**Consultation Response from KC,
 Lead Local Flood Authority**

2020/94203 Clough House, 236, Leeds Road, Birstall, Batley, WF17 0HW

Outline application for demolition of dwelling and associated outbuildings and the erection of 30 dwellings

**Date Responded:
 12/01/2021**

<b>Client</b>				
ROSIE CARR				
<b>Project</b>				
CLOUGH HOUSE, LEEDS ROAD				
<b>Detail</b>				
EXISTING IMPERMEABLE AREA				
<b>Scale</b>	<b>Dwn</b>	<b>Chkd</b>	<b>Date</b>	<b>Dwg No.</b>
1:500	MD		Oct'20	E17/6960/18/01

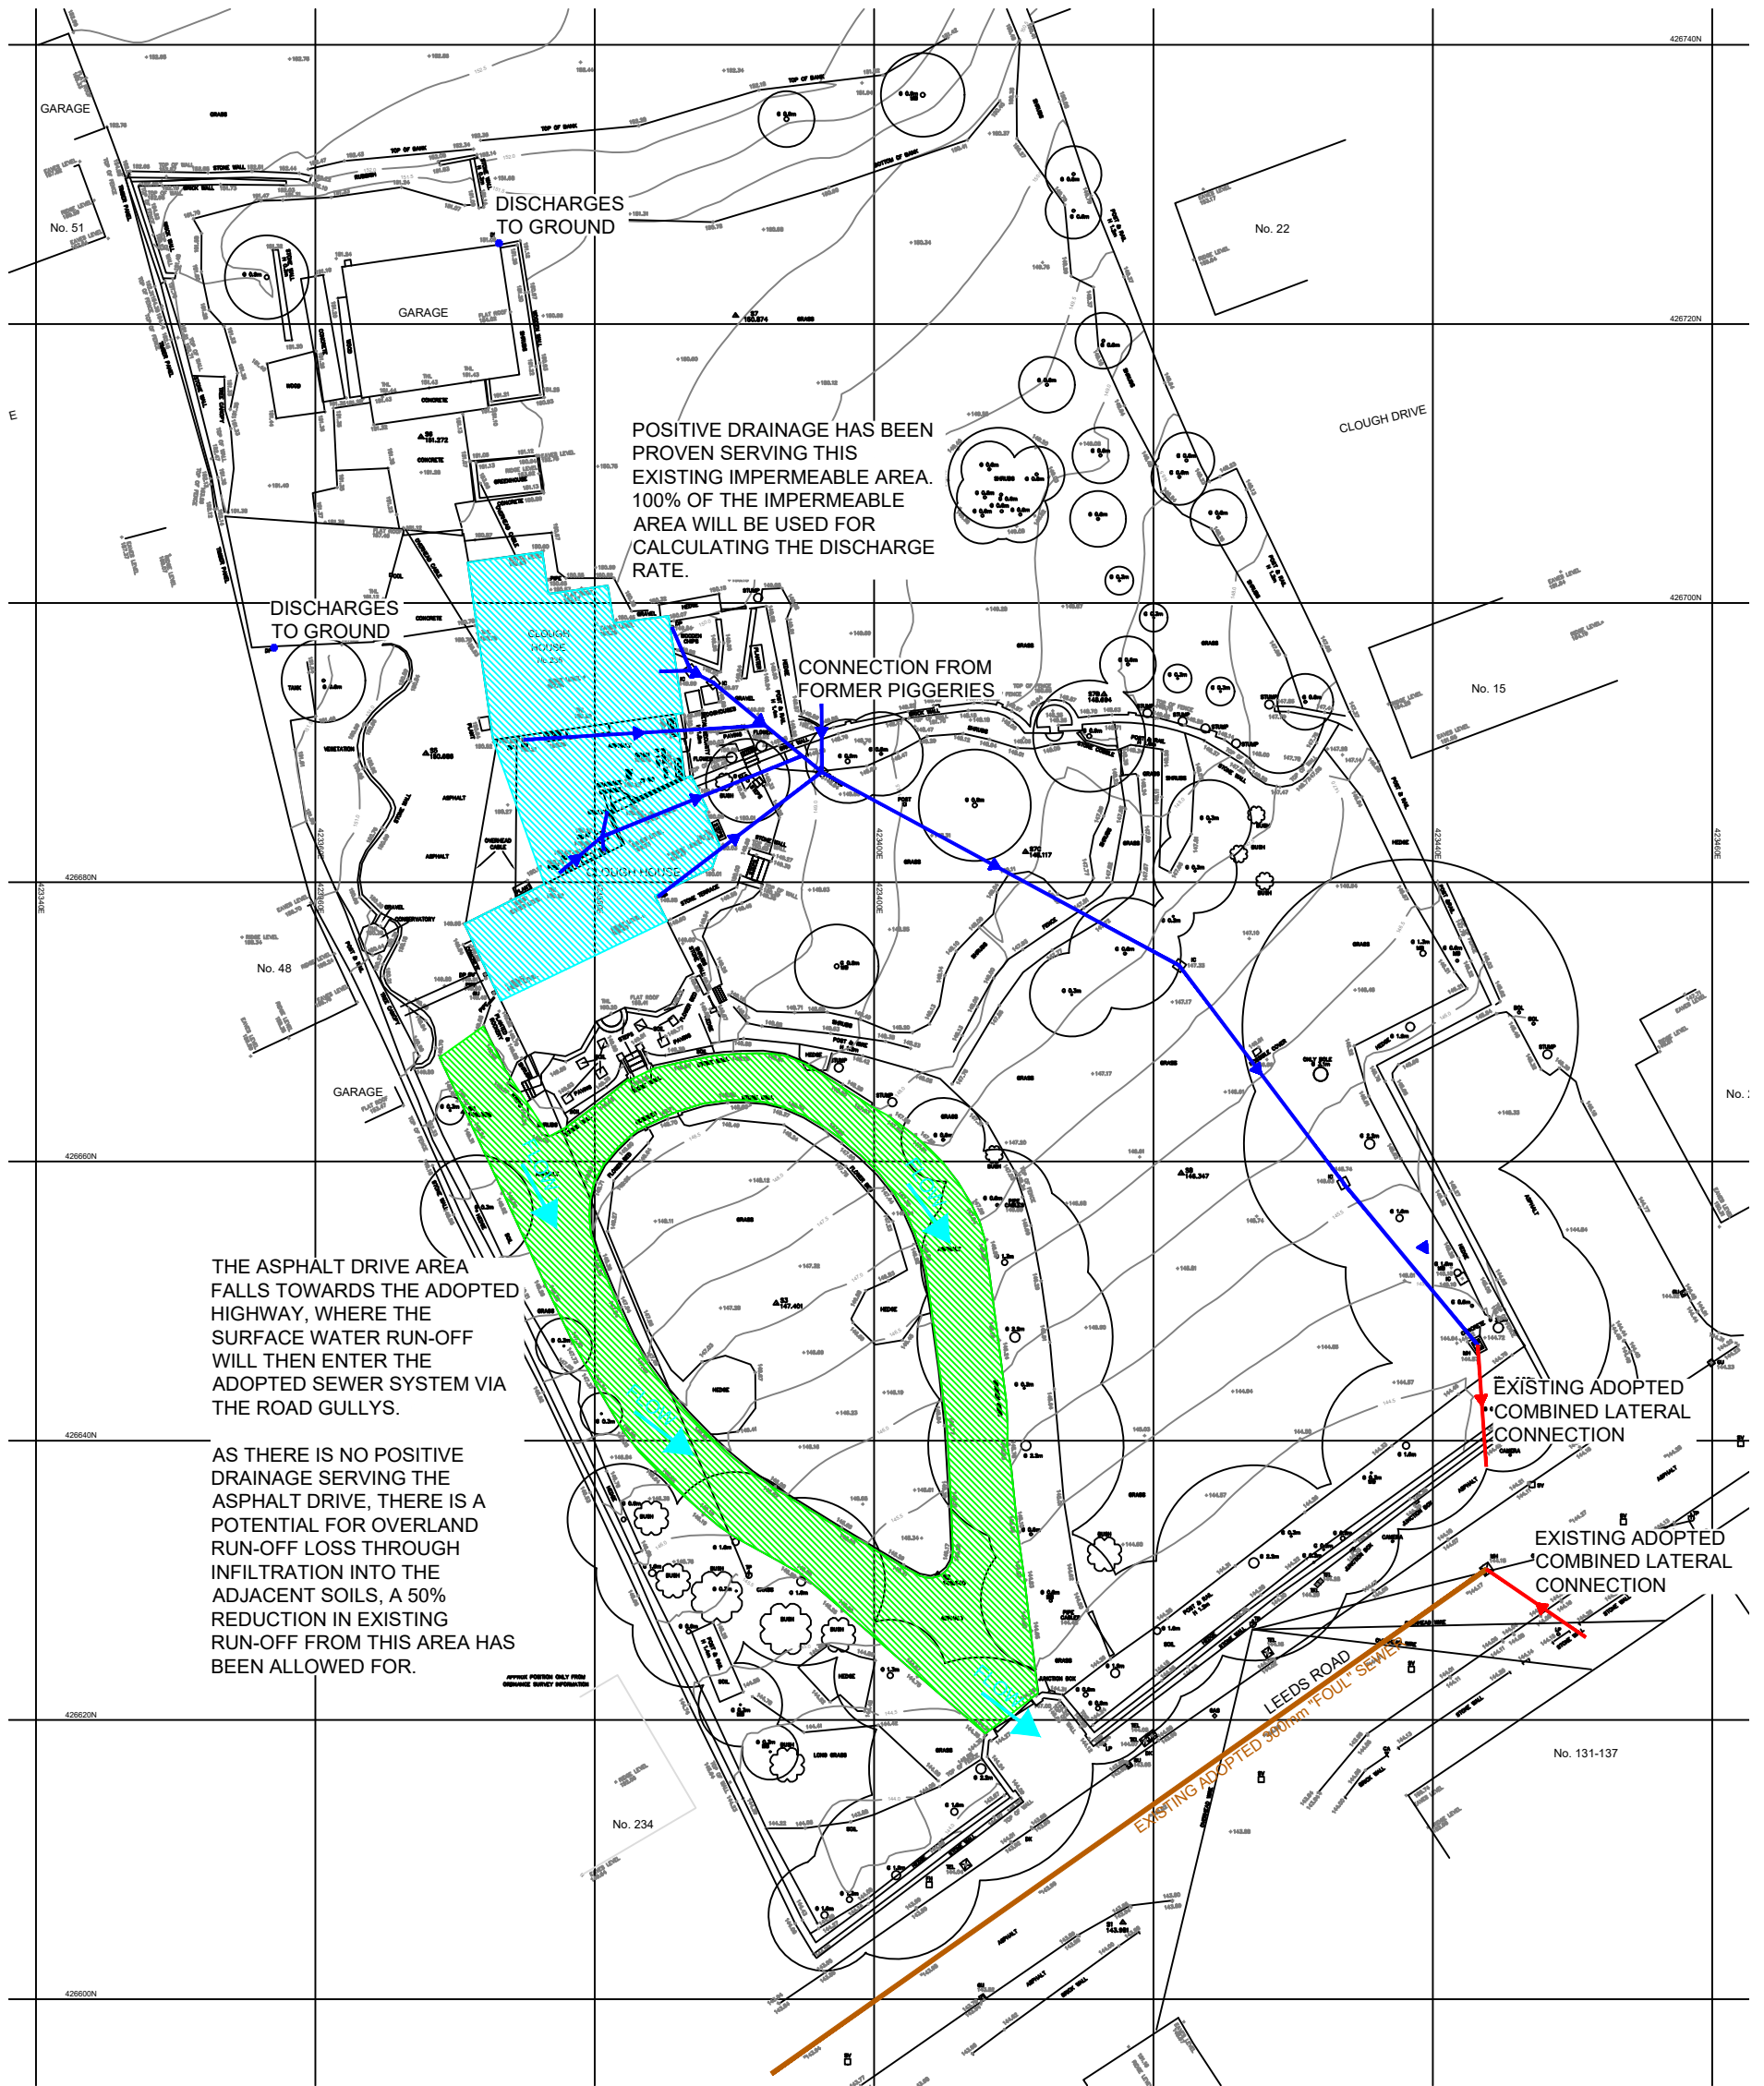
It is noted that the developer proposes to limit the flow off site to 5.0 l/s as noted on the submitted drawing ref E20/6960/01A, however the submitted drainage calculations appear to have been carried out using 6.1 l/s. As the site is predominantly a greenfield site, the LLFA will expect the allowable discharge rate from the site to be as close to the equivalent greenfield run-off rate with a flow rate of 3.0 l/s subject to a minimum flow control device outlet diameter of 100mm (preferred) or 75mm (absolute minimum).

Development shall not commence until a scheme restricting the rate of surface water discharge from the site to a maximum of **3.0 litres per second** has been submitted to and approved in writing by Local Planning Authority. The drainage scheme shall be designed to attenuate flows generated by the critical 1 in 30 year storm event as a minimum requirement. Volume in excess of that generated by the critical 1 in 30 year storm event, up to and including the critical 1 in 100 year storm event shall be stored on site in areas to be approved in writing by the Local Planning Authority. The scheme shall include a detailed maintenance and management regime for the storage facility including the flow restriction. There shall be no piped discharge of surface water from the development and no part of the development shall be brought into use until the flow restriction and attenuation works comprising the approved scheme have been completed. The approved maintenance and management scheme shall be implemented thereafter
